From: Martyn White
Sent: 04 September 2014 14:23
To: James Smith
Subject: EG/55/14/PL, EG/56/14/PL, EG/57/14/A, EG/59/14/PL Comments on revised Plans

Application Number	EG/55/14/PL, EF/56/14/PL, EG/57/14/A, EG/59/14/PL REVISION
Address	The Barnham Hotel 28 Barnham Road Barnham PO22 0ES
Description	Various – See below
Case Officer	Mr. S. Davis

PROPOSED FRONT ELEVATION

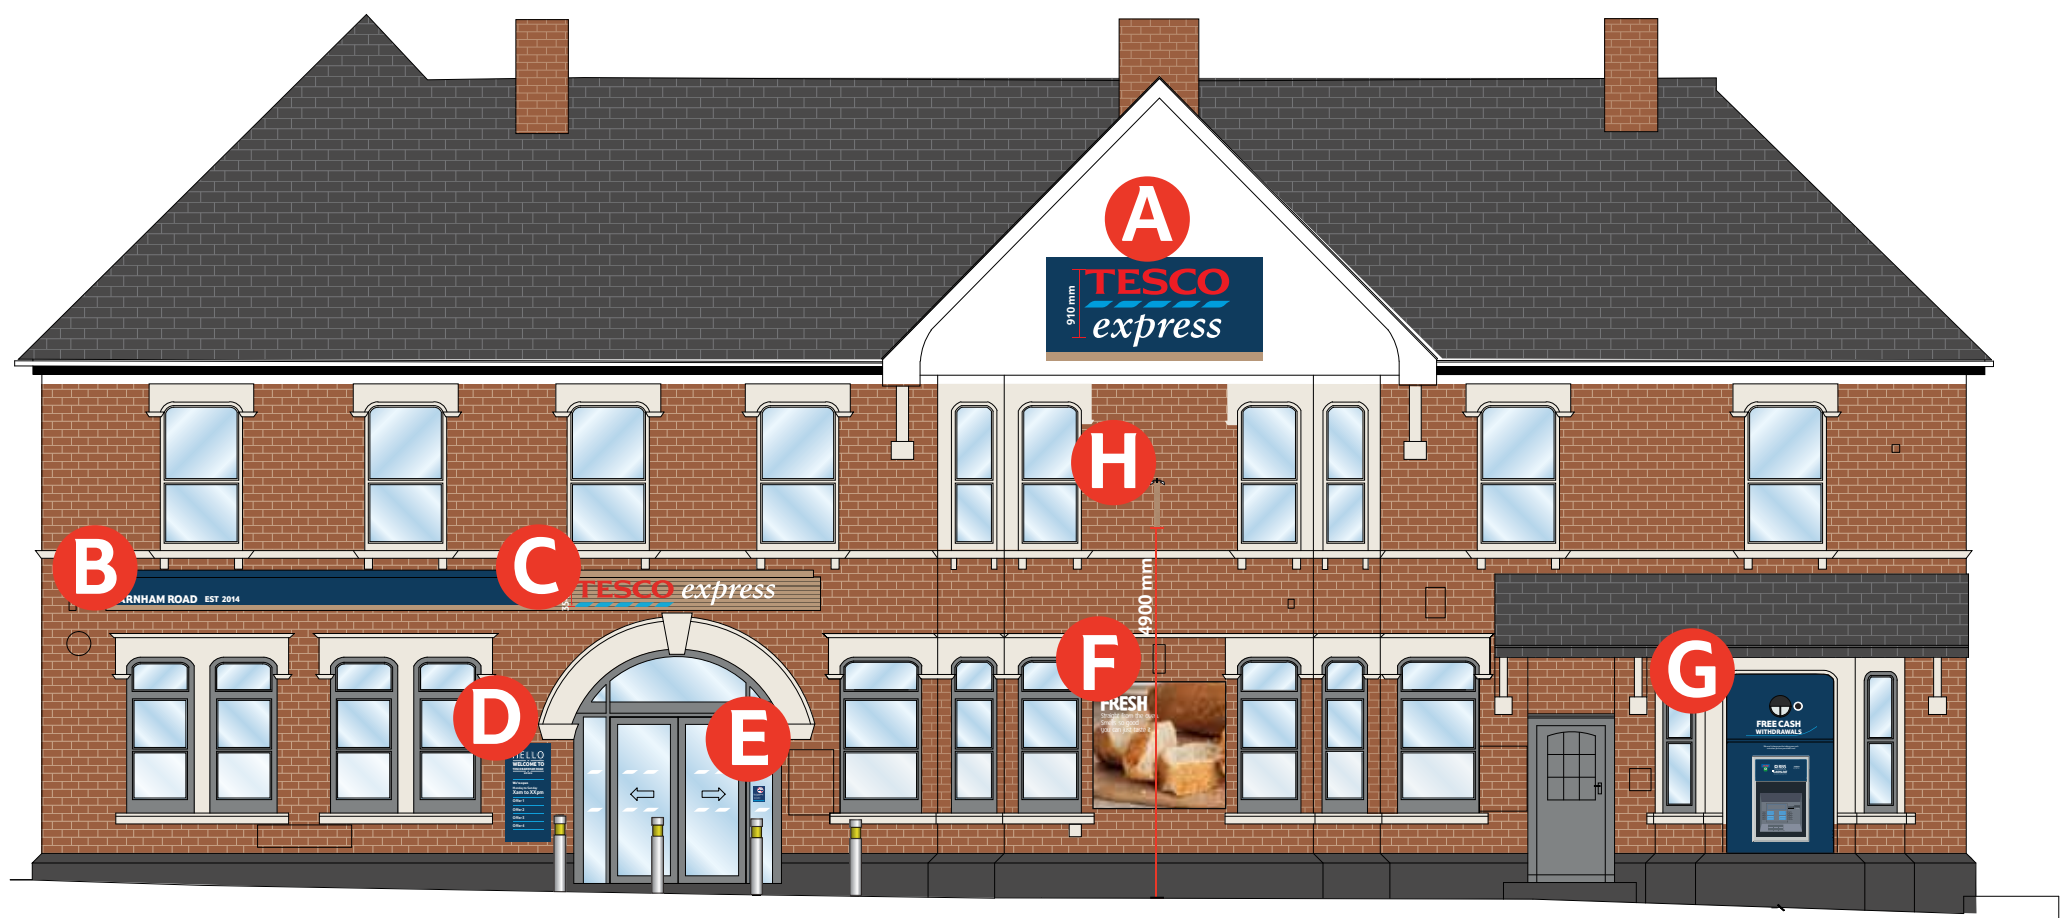
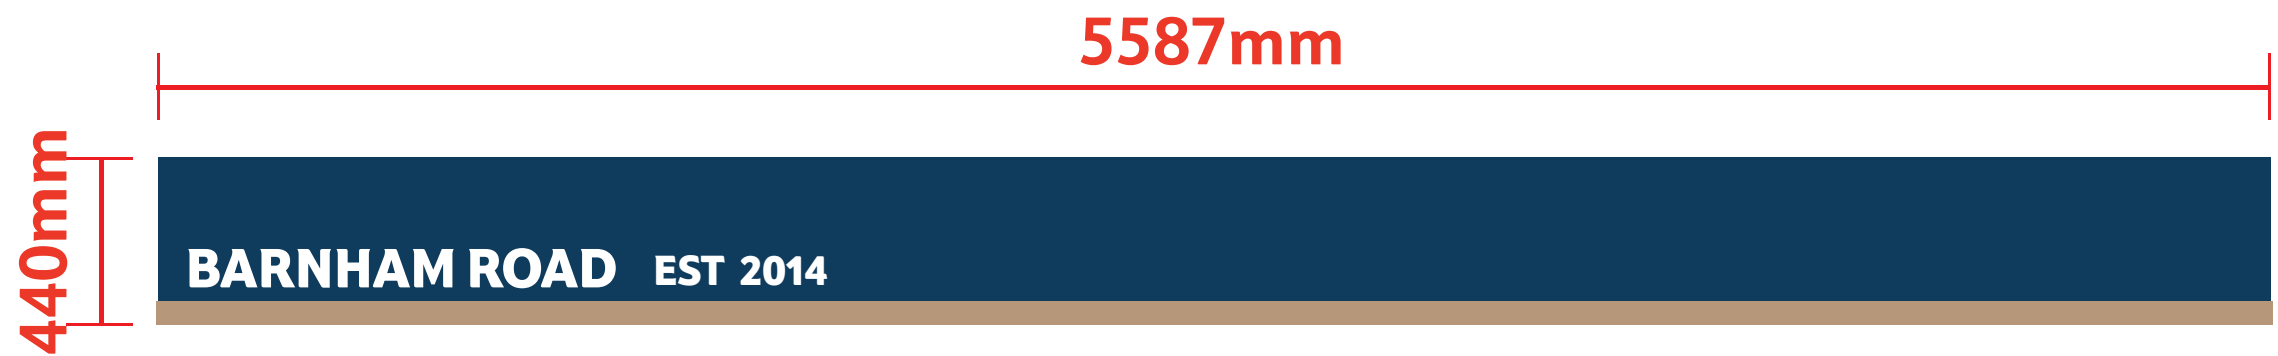
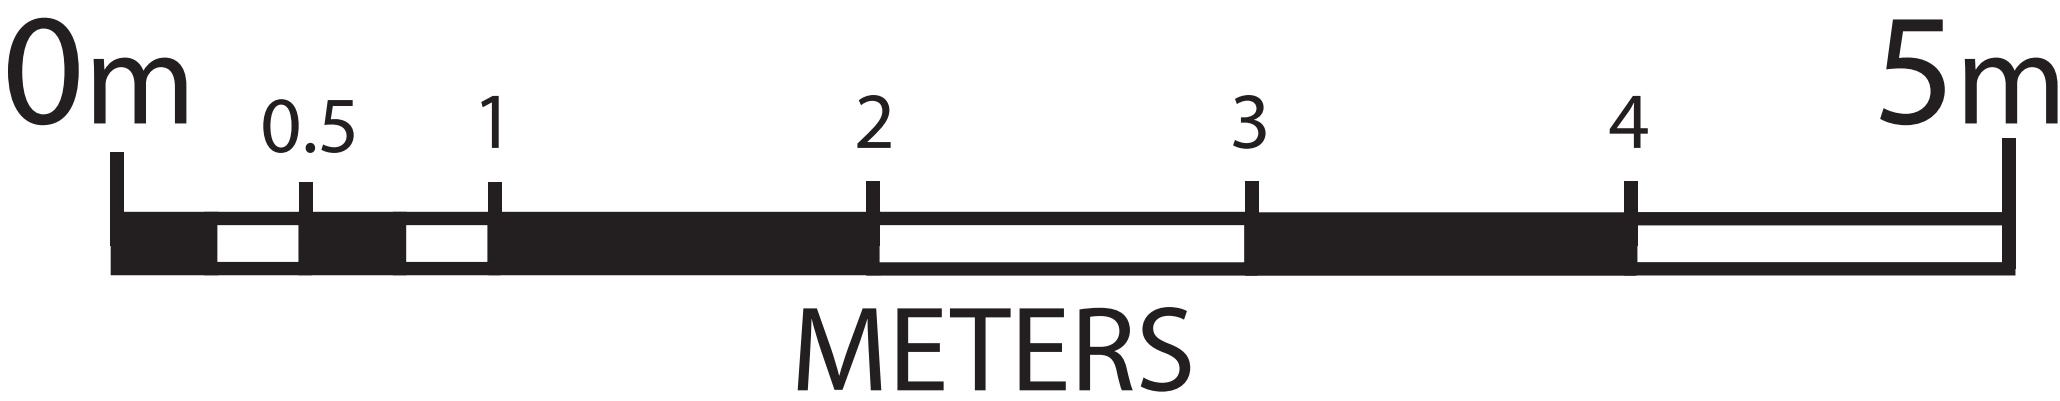
EG/57/14/A: the removal of the sign at the ground floor is supported. However, whilst it is considered that new sign B is acceptable, the concept of lighting it is not required.

PROJECT PROPOSED TESCO EXPRESS BARNHAM BRIDGE INN 28 BARNHAM ROAD, BARNHAM WEST SUSSEX, PO22 0ES			
DRAWING TITLE PROPOSED PLAN			
DRAWN BY MAS	CHECKED BY MBH	DRAWING No.	REV
SCALE 1:100@A1	DATE AUG 14	9782-811

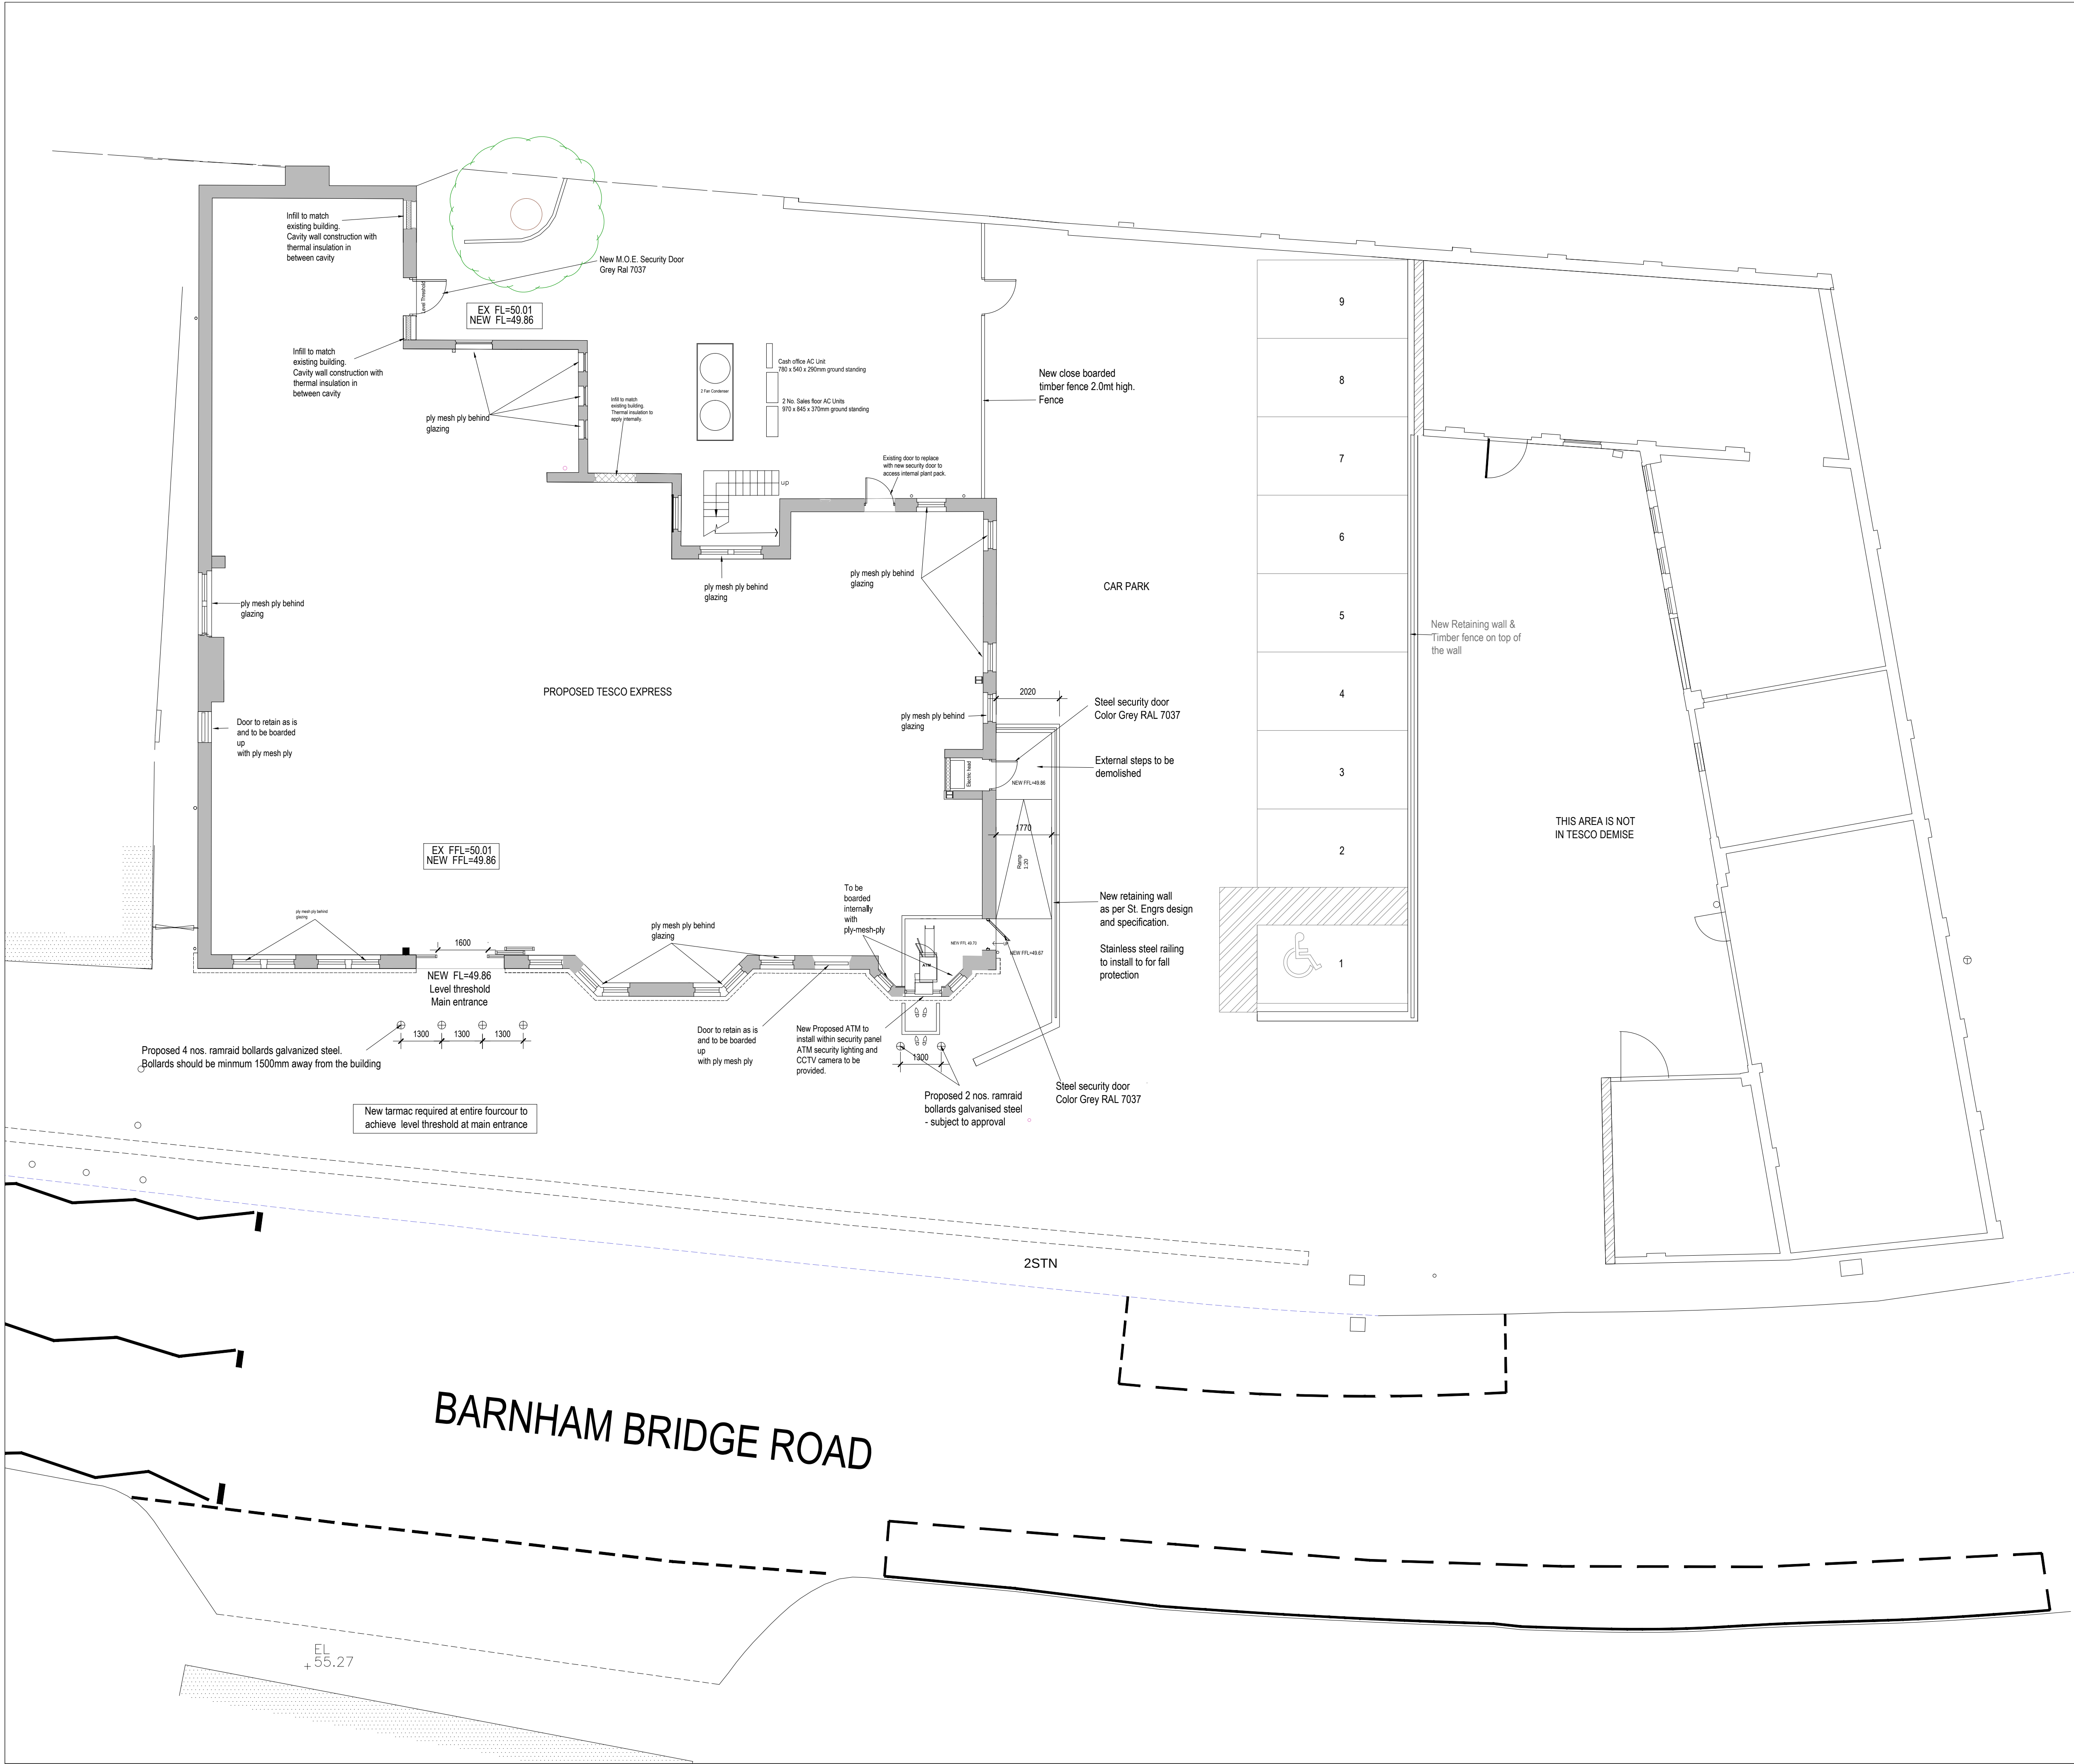
EG/59/14/PL: it is considered that the bollards are of a standard design and should be more relevant to the property. This can be dealt with by condition.
